EP-24-0010 Owl Marketplace Filing 1
NE¼ SE¼ Section 1, T13S, R65W, 6th Meridian
39.9459, -104.6082
File Number: VR2321
Final plat to create one residential lot into five (5) commercial lots.

With this referral, we received a request to provide Review Comments (Email dated November 2, 2023); Construction Drawings (Drexel, Barrell & CO., August 4, 2023); Final Drainage Report (Drexel, Barrell & CO., August 2023); Final Plat (Drexel, Barrell & CO., May 30, 2023); Soils and Geology Study (Entech Engineering, Inc., June 22, 2023); and other documents.

Sheet 2 of 3

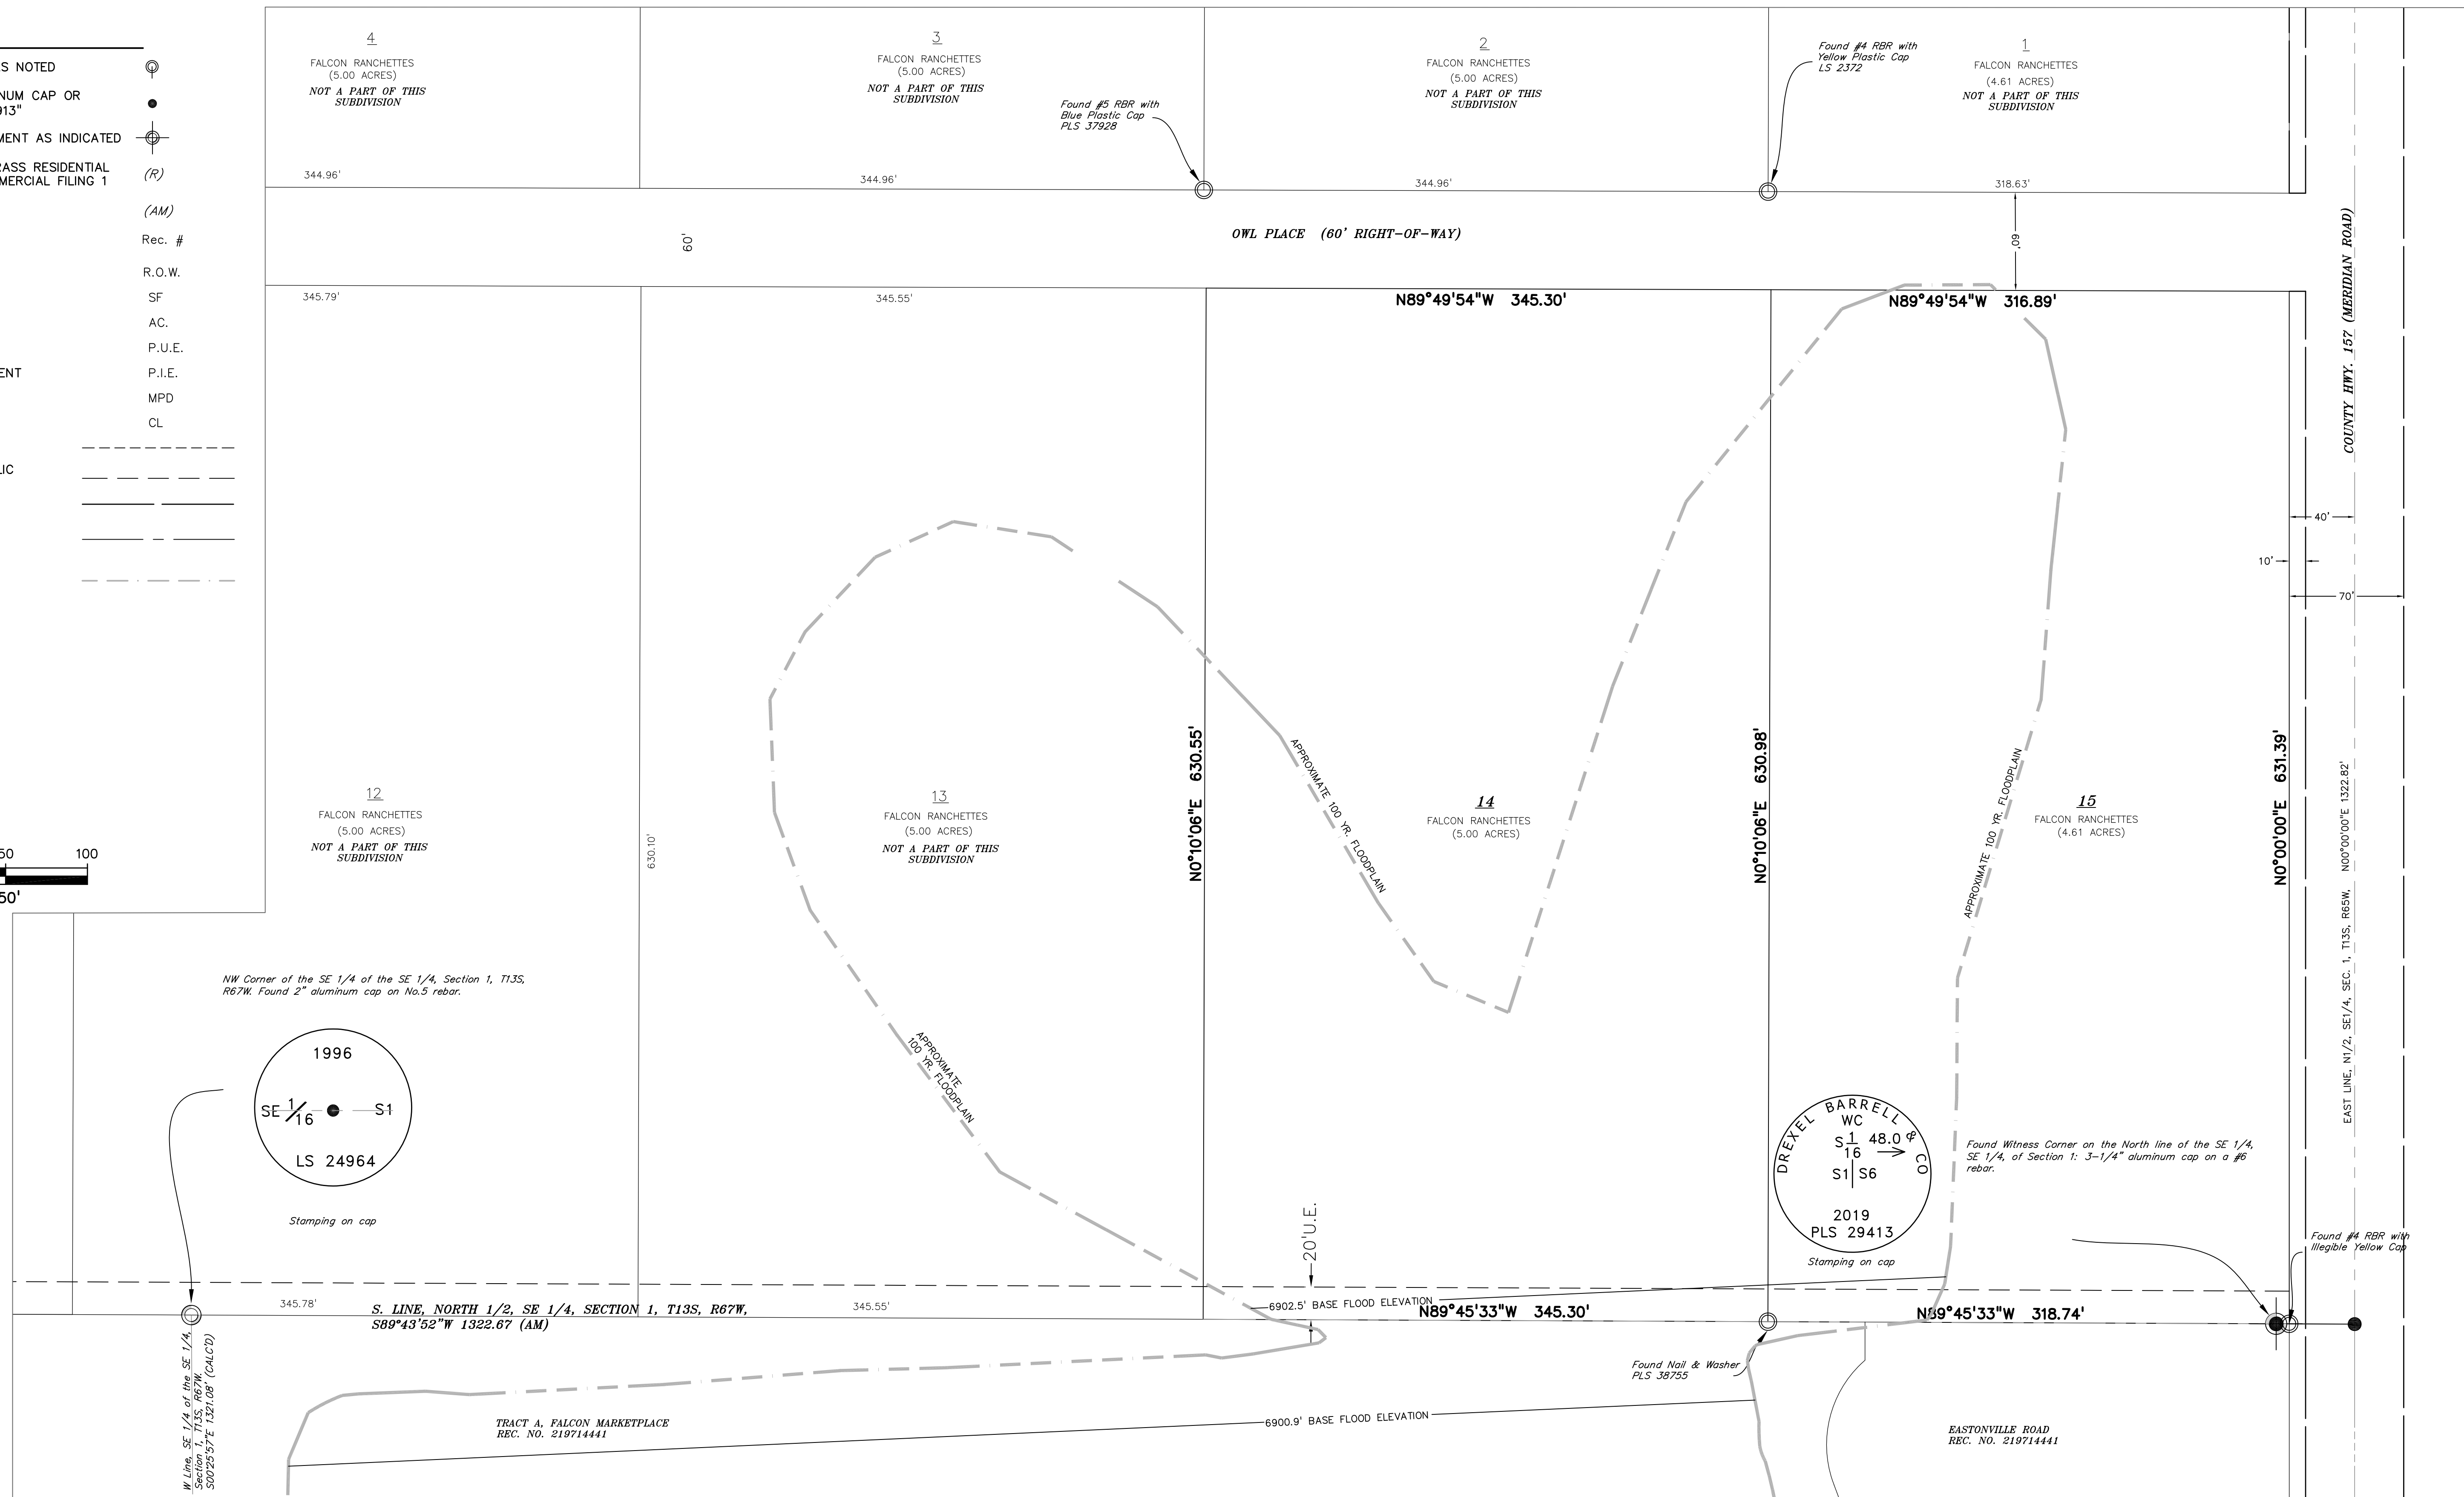
2. The FEMA floodplain (Zone A) is associated with a large majority of the site. Based on the referral documents, a 10' x 6' box culvert will be installed to reroute the drainage around the northern and western sides of the site. Even so, the updated FEMA floodplain easement and any setbacks should be included in the final plat.

JOB NO.
230745
FIG. 6

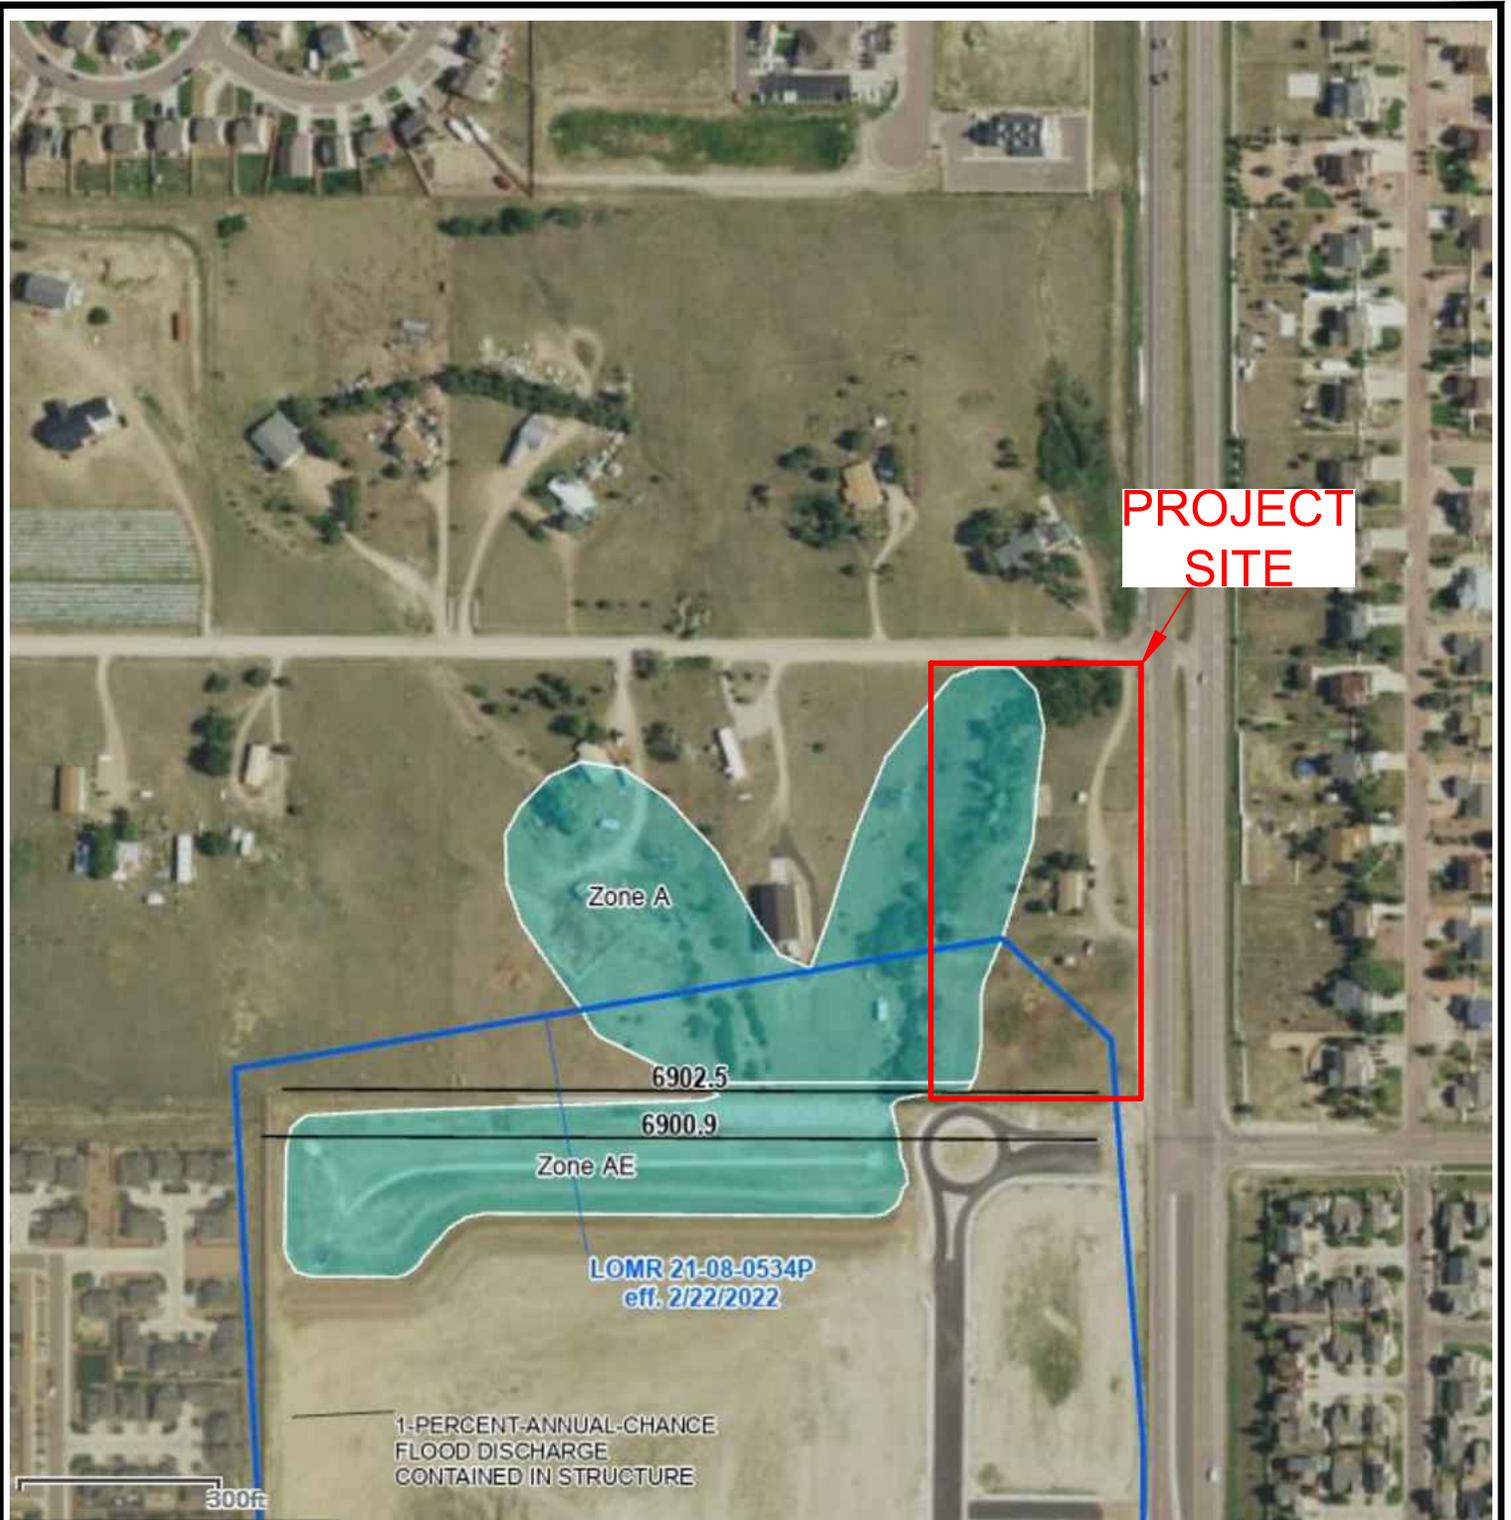
1. Entech's Figure 6 shows geologic hazards and constraints within certain areas of the property. However, only Tbs (Black Squirrel Formation) is shown in the eastern portion of the lots. Based on our review of Entech's boring logs, seasonal shallow water and expansive soils should also be included in this area. The legend should be updated to include missing symbols (sw, fp, and w) and the correct description of Tbs (Black Squirrel, not Pierre Shale). CGS recommends that Figure 6 be updated and a note added to the final plat listing the geologic hazards and constraints, along with mitigation measures.
